From: Euan Clark - Folkes Architects [REDACTED]
Sent: 10 December 2019 14:52
To: Anita Gardner <Anita.Gardner@arun.gov.uk>
Subject: RE: 10053: Toddington Lane Littlehampton, Arun District, BN17 7PN APP/C3810/W/18/3197149 (LU/162/17/PL) Condition 14

Having double checked through the drawings, it looks like GTA Civils have prepared a new drawing (ref: 304) which has been prepared to specifically address condition no.14. The other drawing confirms the extent of Highway owned land, and was sent to WSCC for their information.

I am contacting you in regards to the development at Toddington Lane (LU/162/17/PL) and condition 14. In your comments on 15th October 2019 you asked for A visibility splay of 2.0m * 66m in both directions at the western end of the proposed footway. This was to ensure any pedestrians crossing in this location have sufficient visibility to see any oncoming cars. The 66m visibility splay is achievable looking west but not looking east.

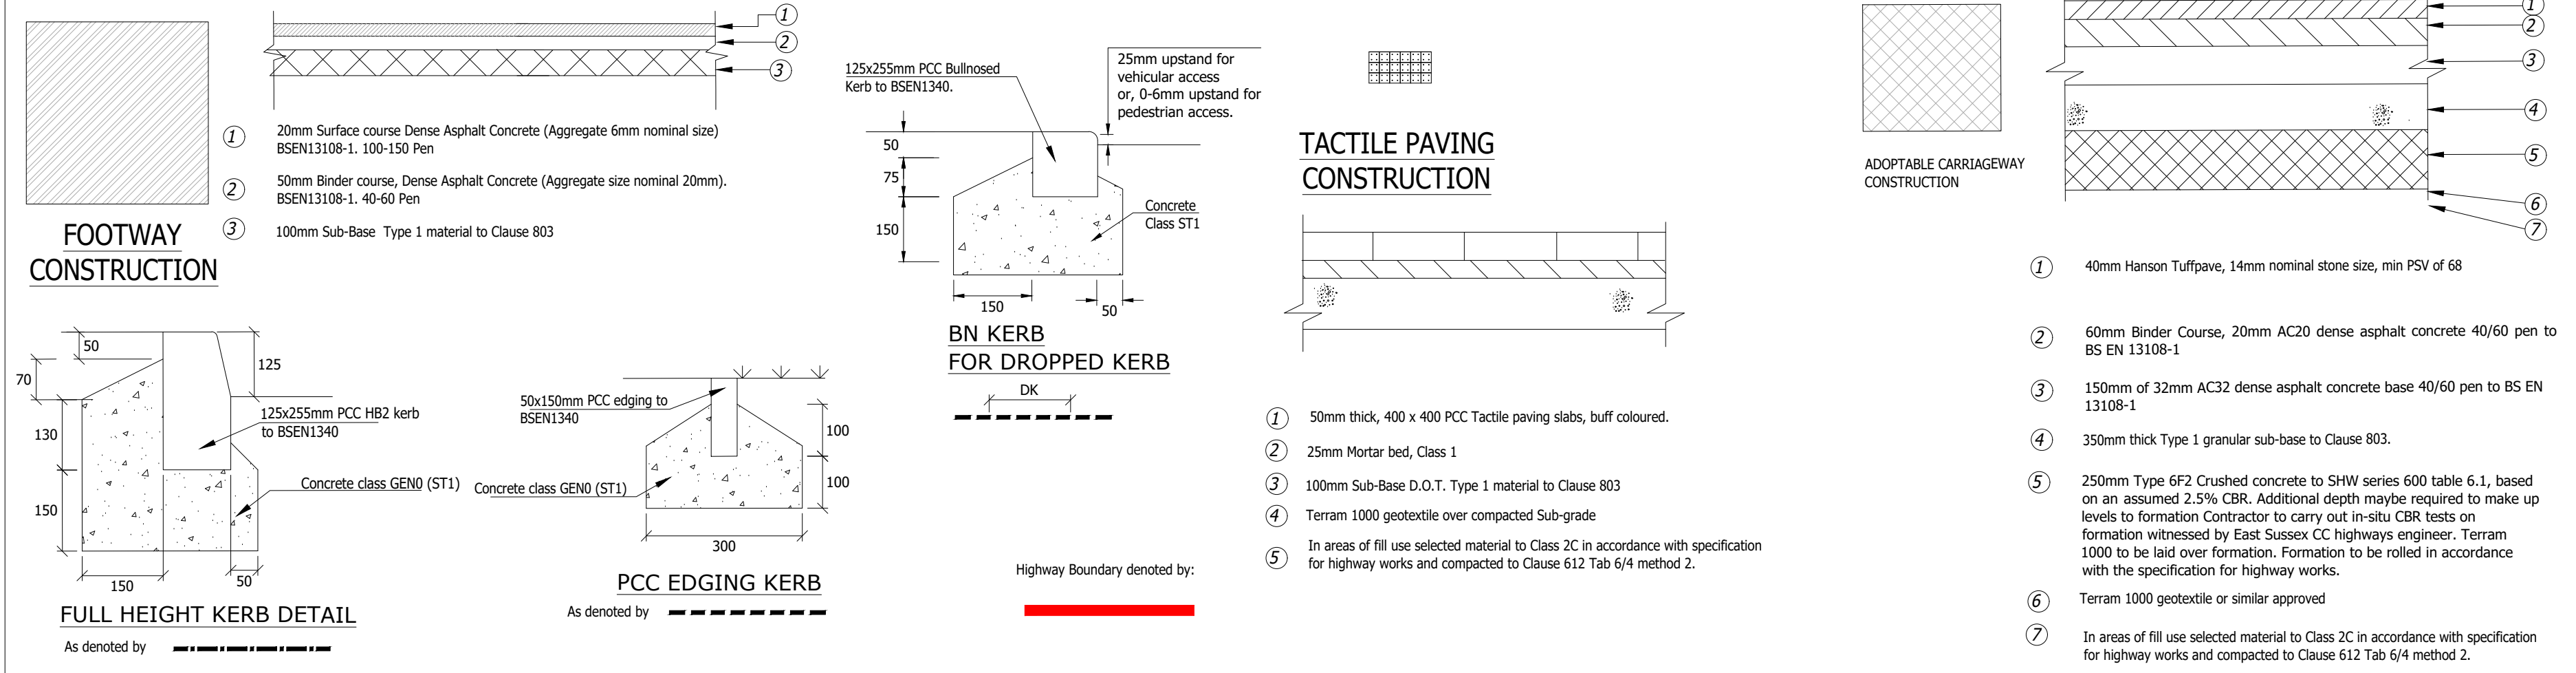
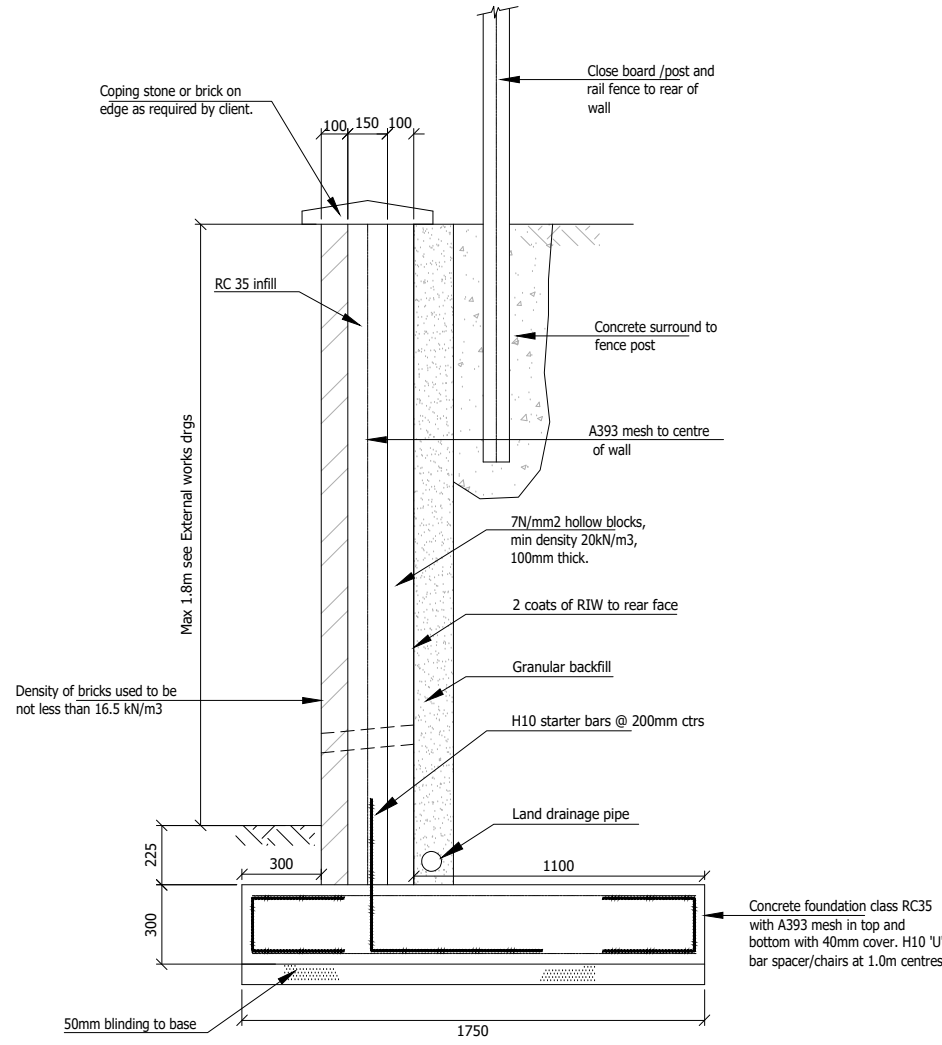
In principle I think we could accept the 1 metre. However just one point I would like to confirm, the 66 metre splay to the west can you confirm in a bit more detail it is all contained within highway land as it present it is not stated.

Thank you for your response. Please see Pedestrian visibility splay plan and highway boundary information attached.

In order to ensure that the visibility splay looking west is entirely within highways land we can only guarantee a 59m visibility splay. In regards to this I would refer to my email to Tim from 19th November:

As such I would contend the 59m visibility splay entirely within the highway boundary should be acceptable.
